WEST SUSSEX COUNTY COUNCIL CONSULTATION

TO:	Arun District Council FAO: Amber Willard
FROM:	WSCC - Highways Authority
DATE:	2 July 2019
LOCATION:	38 Chalcraft Lane, Bognor Regis, PO21 5TX
SUBJECT:	BE/47/19/PL Addition of first floor to existing bungalow to allow conversion to 2 x 1 bedroom flats and a studio flat.
DATE OF SITE VISIT:	N/A
RECOMMENDATION:	Advice
S106 CONTRIBUTION TOTAL:	£N/A

PROPOSED SITE LAYOUT 1:200

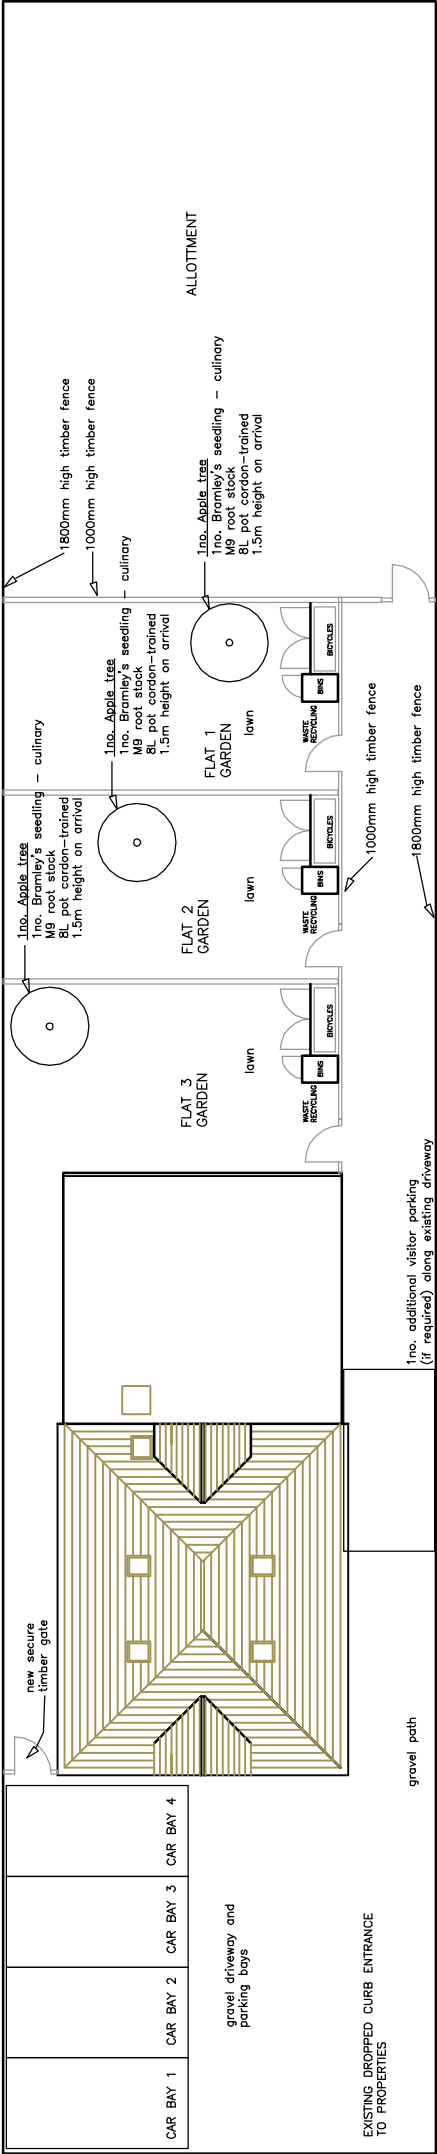
3 car parking spaces are proposed for the 3 flats, with an additional 3 spaces for visitors. The WSCC Car Parking Demand Calculator indicates that the proposed flats would create a demand for at least 4 car parking spaces. The plans therefore demonstrate a sufficient amount of off-street parking provision to meet the needs of the properties.

Turning on-site may be achievable using a multi-point manoeuvre. However, vehicles may have exit the site onto Chalcraft Lane in a reverse gear. Given that this is the existing arrangement for this property and has operated safely prior without incident, this not anticipated to cause a severe highways concern.

Cycling is a viable option in the local area. Secure and covered cycle parking for 3 cycles is proposed in the plans. The inclusion of cycle storage increases the sustainability of the property by offering alternative modes of transport to the private car.

No part of the development shall be first occupied until the car parking has been constructed in accordance with the approved site plan. These spaces shall thereafter be retained at all times for their designated purpose.

No part of the development shall be first occupied until covered and secure cycle parking spaces have been provided in accordance with plans and details to be submitted to and approved by the Local Planning Authority.
